Planning Application Ref: AW/268/21/T

Location: Malmayne Court, Aldwick Fields, Aldwick, PO21 3SW

Description of works: Ash (T1). Fell due to terminal disease. Replant with one standard specimen of a suitable species

MALMAYNE COURT, ALDWICK FIELDS, BOGNOR REGIS
PO21 3SW

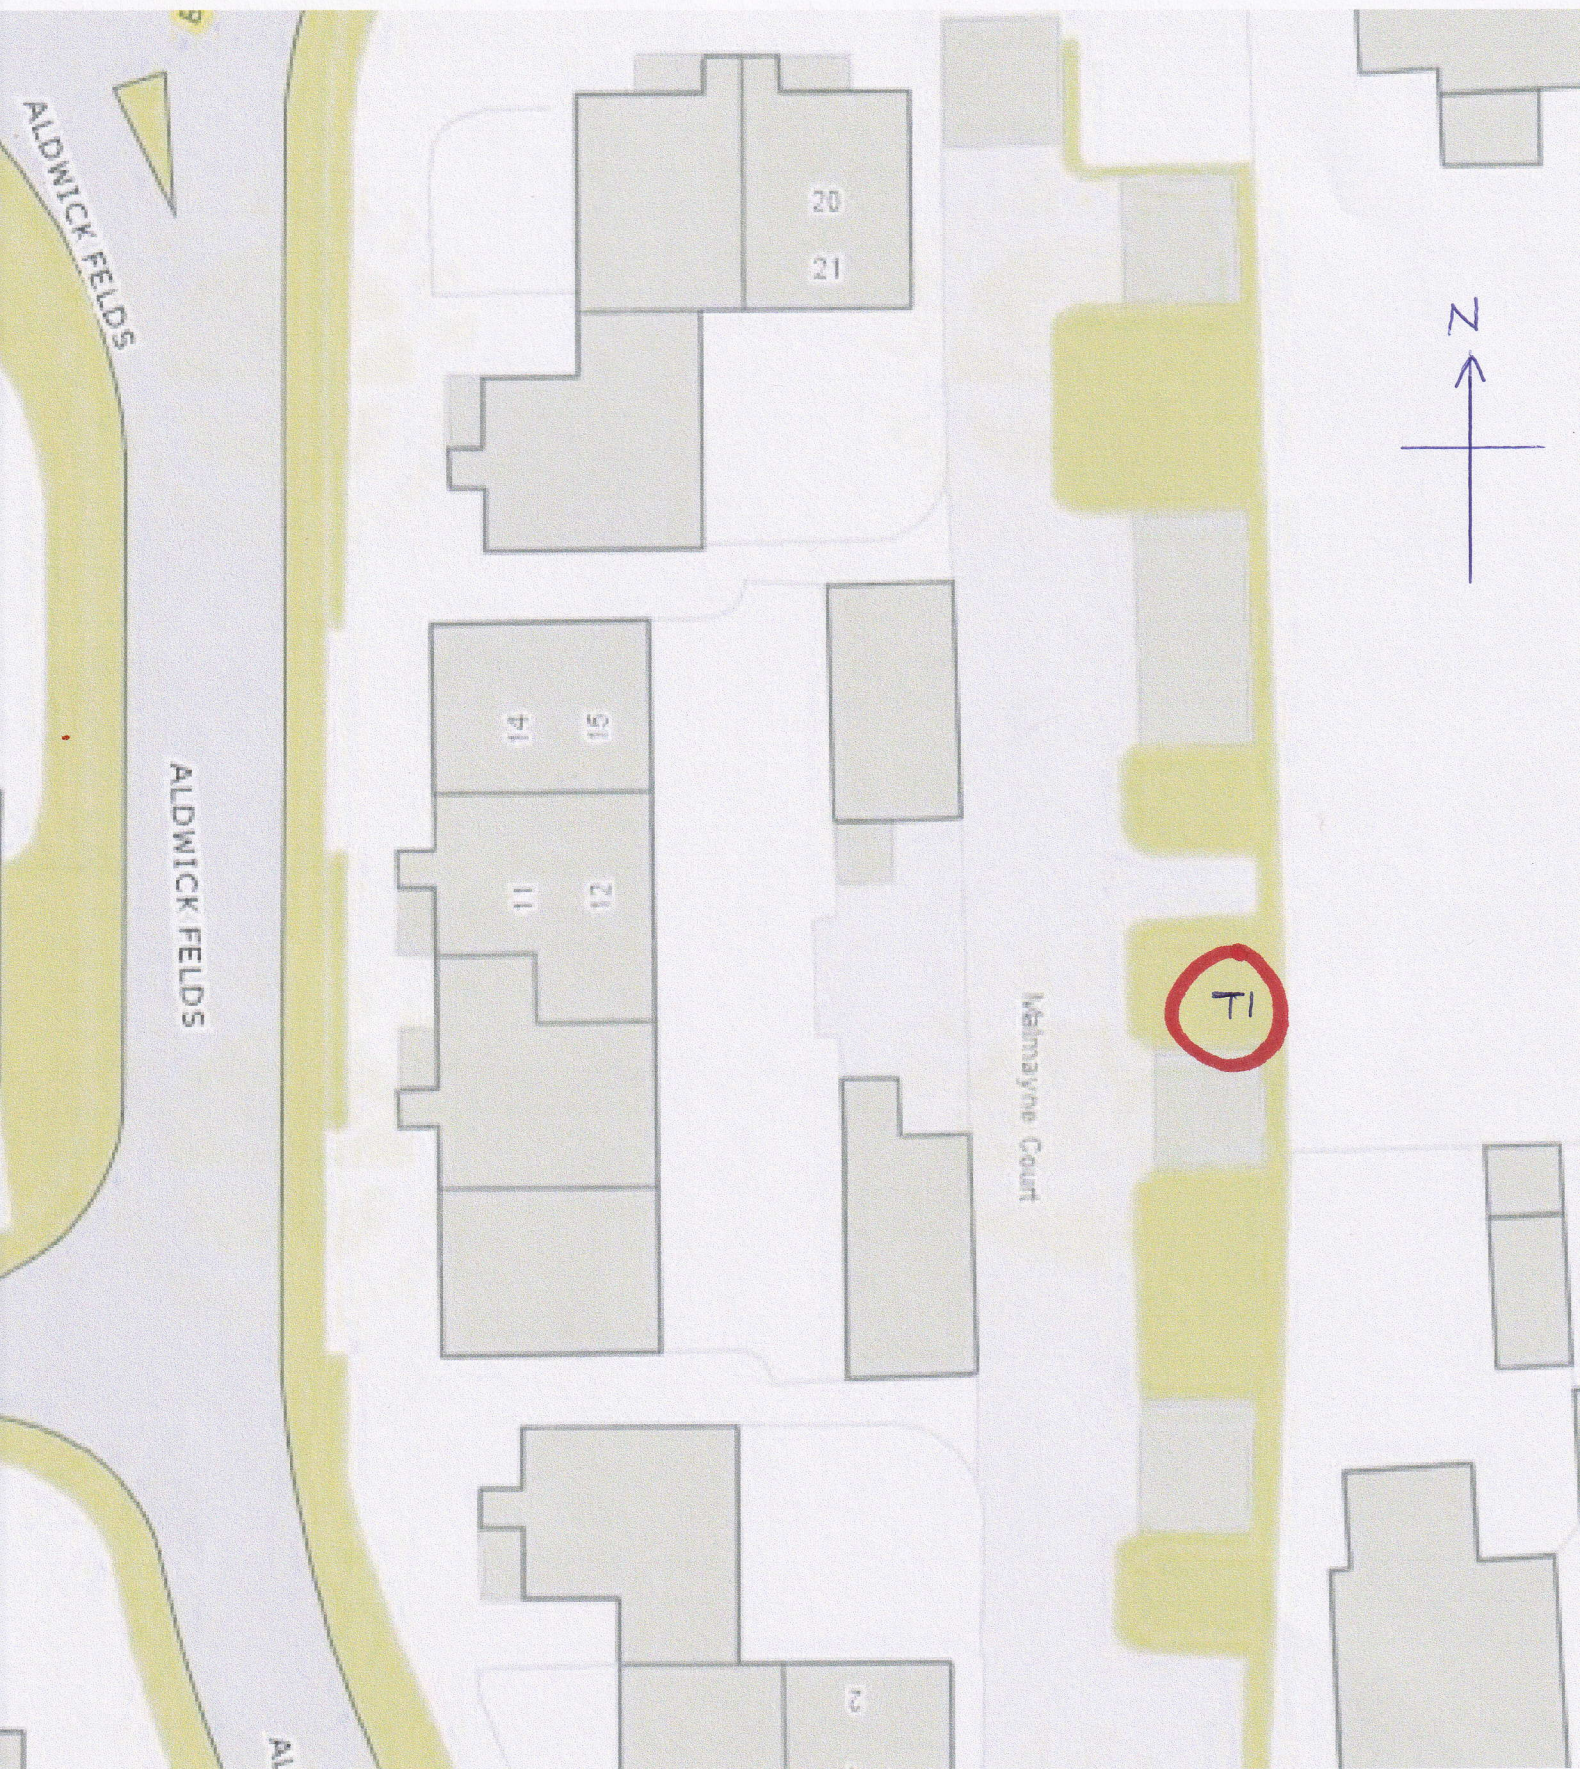
- This is an established tree with an unmodified and attractive upper crown profile. It appears to have suffered physiological decline in the last couple of years. The reason(s) for this may be complicated, as I have been unable to confirm the presence of Chalara ash dieback (although some typical symptoms present) and disturbance over its rooting zone has occurred during development of the neighbouring property.
Note: root dysfunction typically presents as dieback from the crown periphery.
- Crown density is moderate, with scattered tip dieback although some signs of physiological fortitude in lower and interior branches. The tree appears generally sound and stable whilst dead branches present a developing risk of harm to persons or property. The removal of deadwood is an exception and does not require consent from the local planning authority.

- The tree is clearly under physiological stress, but we are not availed of a satisfactory prognosis. As our understanding of *Chalara ash dieback* increases, in particular the varying degrees of resistance in individuals and potential for recovery post-infection; there ought not to be a presumption to fell those trees which present symptoms typically associated with confirmed cases – unless health and safety exceptions apply.
- If the tree is highly valued by the landowner/management, then it may be appropriate to undertake removal of major deadwood and monitor condition, with a final determination likely to be necessary next summer. Alternatively, it may be considered an opportunity now to remove the tree and replace with a tree type more appropriate for the location and which can adapt to the altered environment.

Once the tree has been felled (and either grubbed or ground out) then a replacement tree is to be planted in the same place or nearby and to within 3metres.

This is to be of Standard Nursery Stock proportions (10-12cm girth & 2m to 3m overall height) supported on a 'short stake' system with appropriate securing ties and pads.

It is to be planted within 12 months of the removal of the ash tree.
